Planning Department
Arun District Council
1 Maltravers Road
Littlehampton
BN17 5LF

Objection to planning application P/58/19/PL

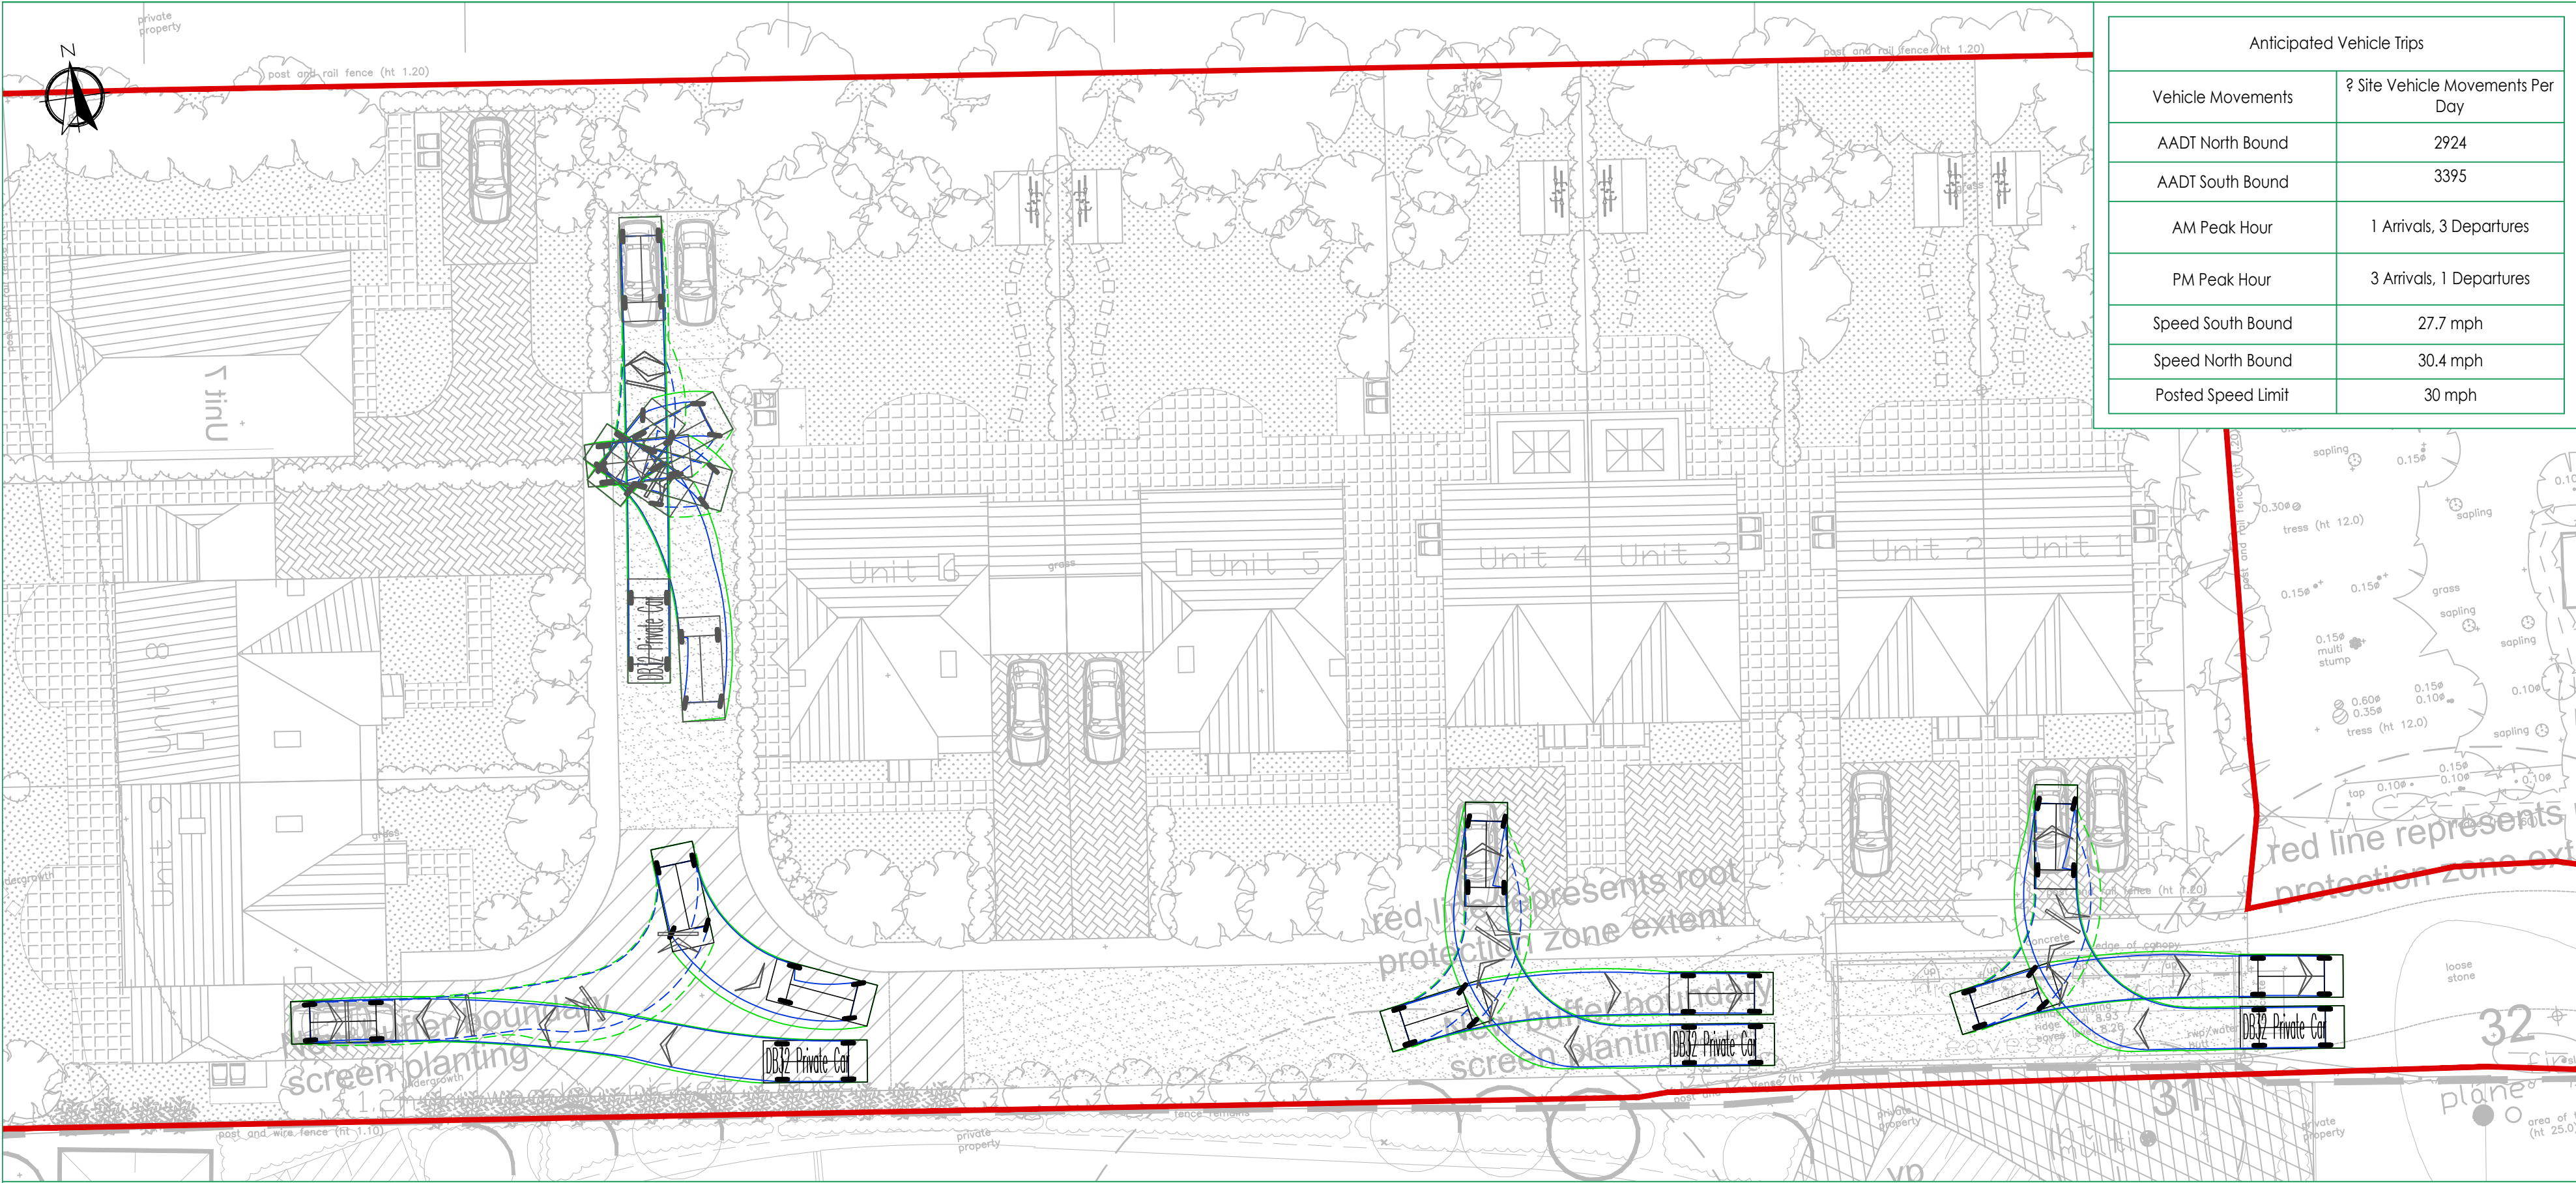
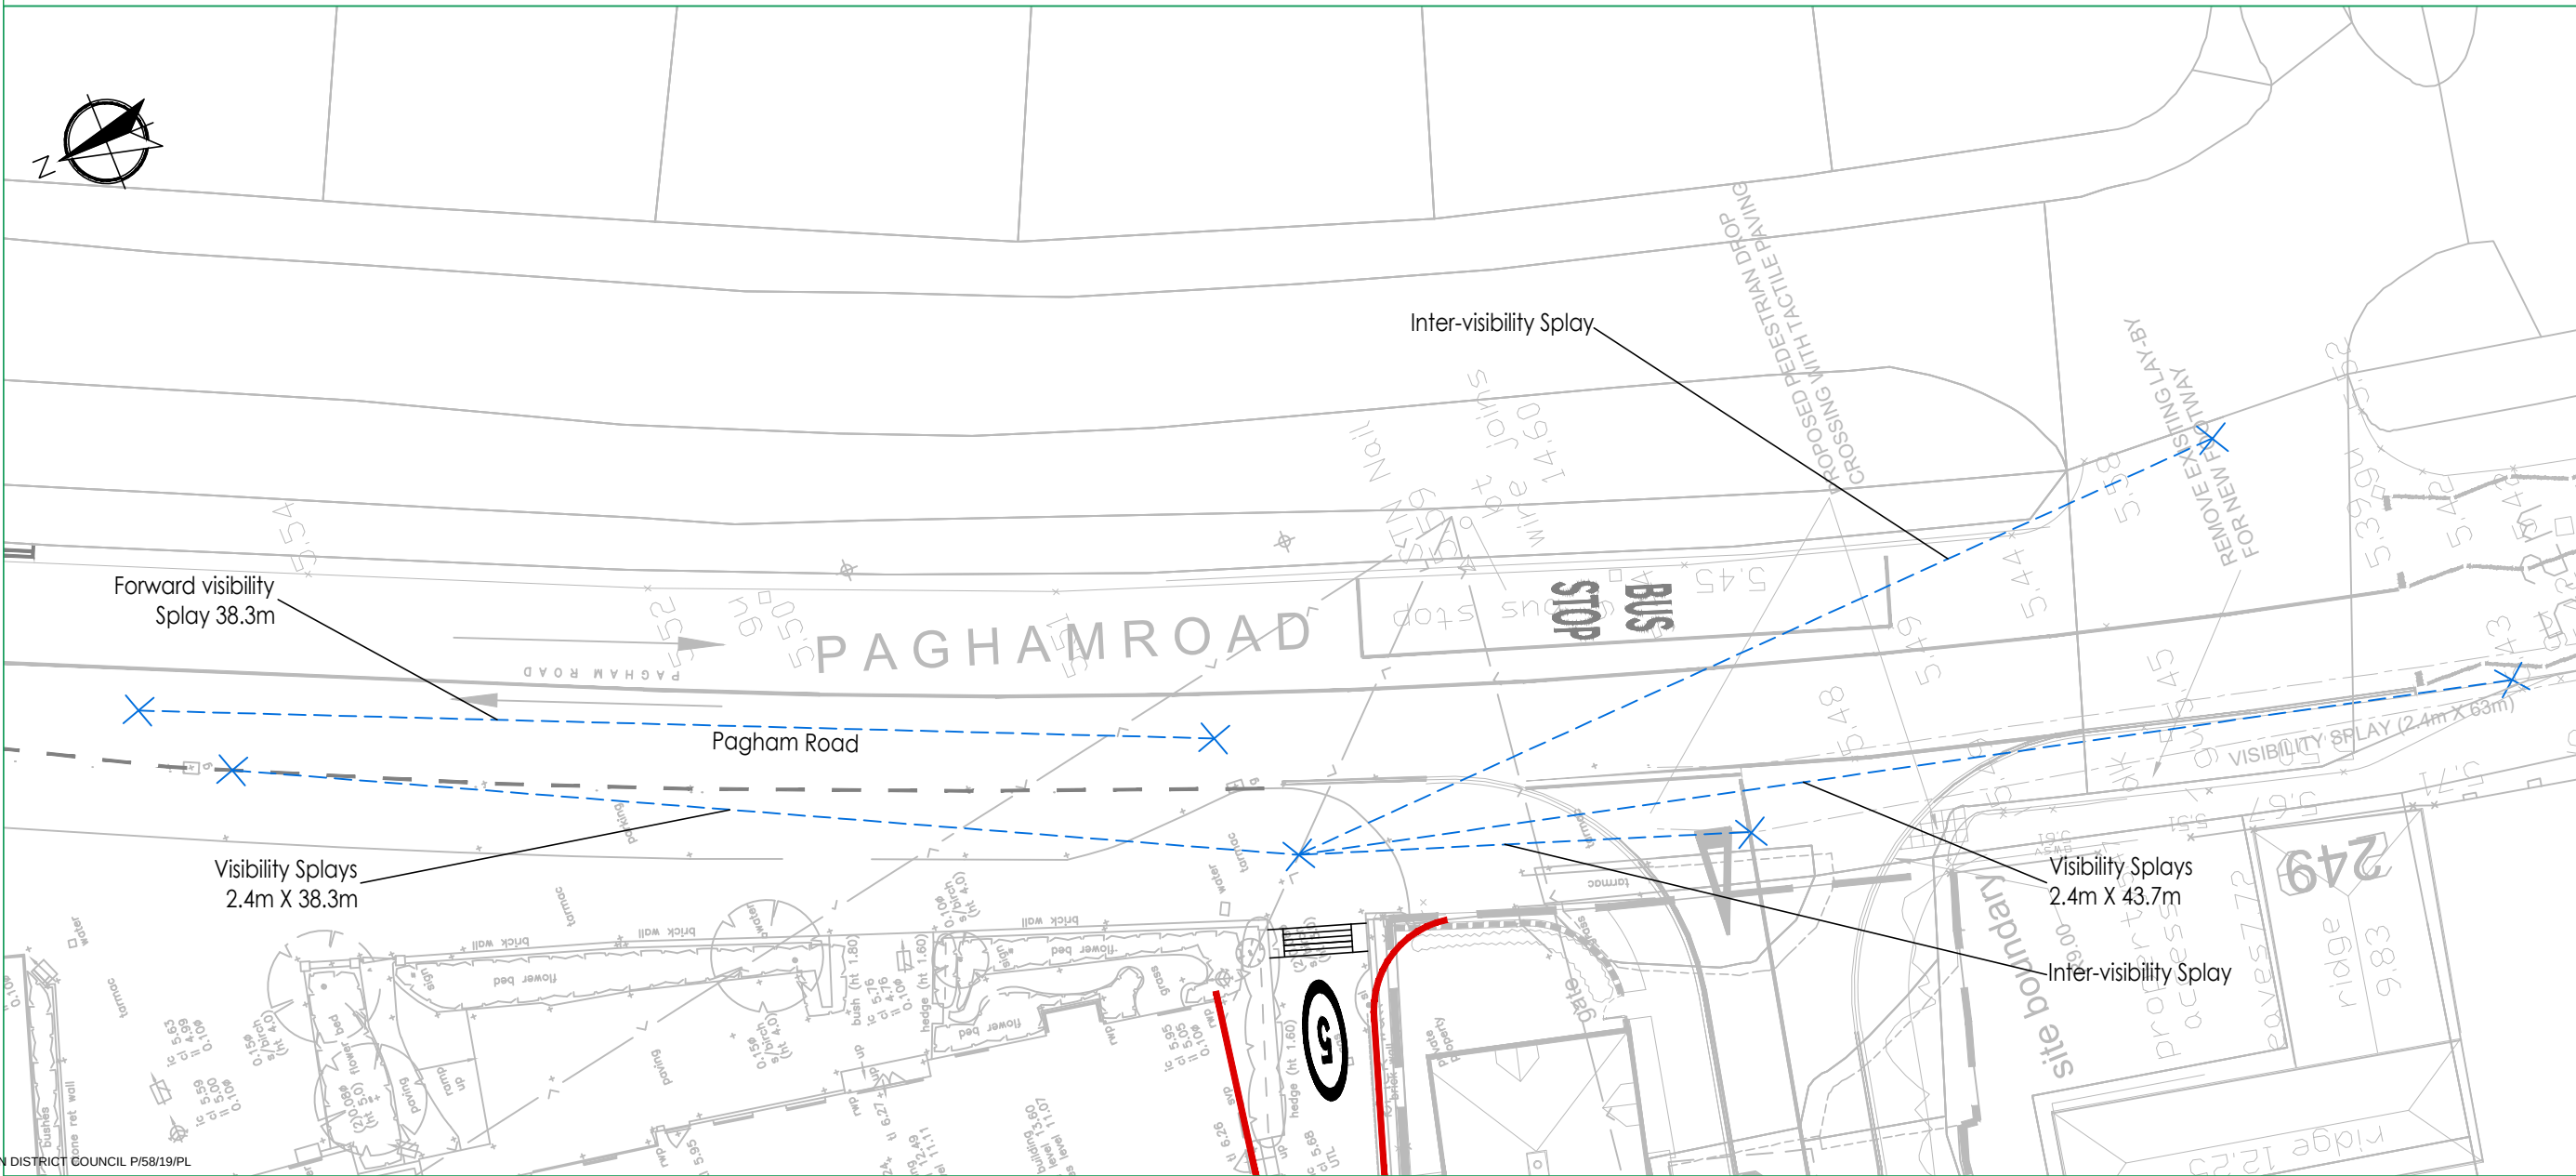
- There are no detailed drawings showing actual measurements of the width of the entire lane before and after alterations have been made and does not address the steps from the Hotel into the lane.

- The access lane needs to be wide enough for a large vehicle to pass a pedestrian safely, i.e Tesco delivery van, online delivery vans such as UPS or a large car (which can be a width of 2.4m).

- The proposed red/green light system is totally flawed. Pedestrian will not abide by the lights system and could be in the lane whilst large vehicles are coming through such as, refuse trucks, DPD, Tesco delivery vans, emergency vehicles (all in a hurry) who have been waiting at a red light while someone comes trundling out in the opposite direction. More than one vehicle trying to access the site will result in cars parked on the pavement and in the Pagham Road at its narrowest point. It's a recipe for disaster.

- A traffic light system is NOT a practical and viable solution to a narrow lane at this location.
- Due to parking in the layby there is a restricted view from the north for traffic exiting onto the Pagham Road.
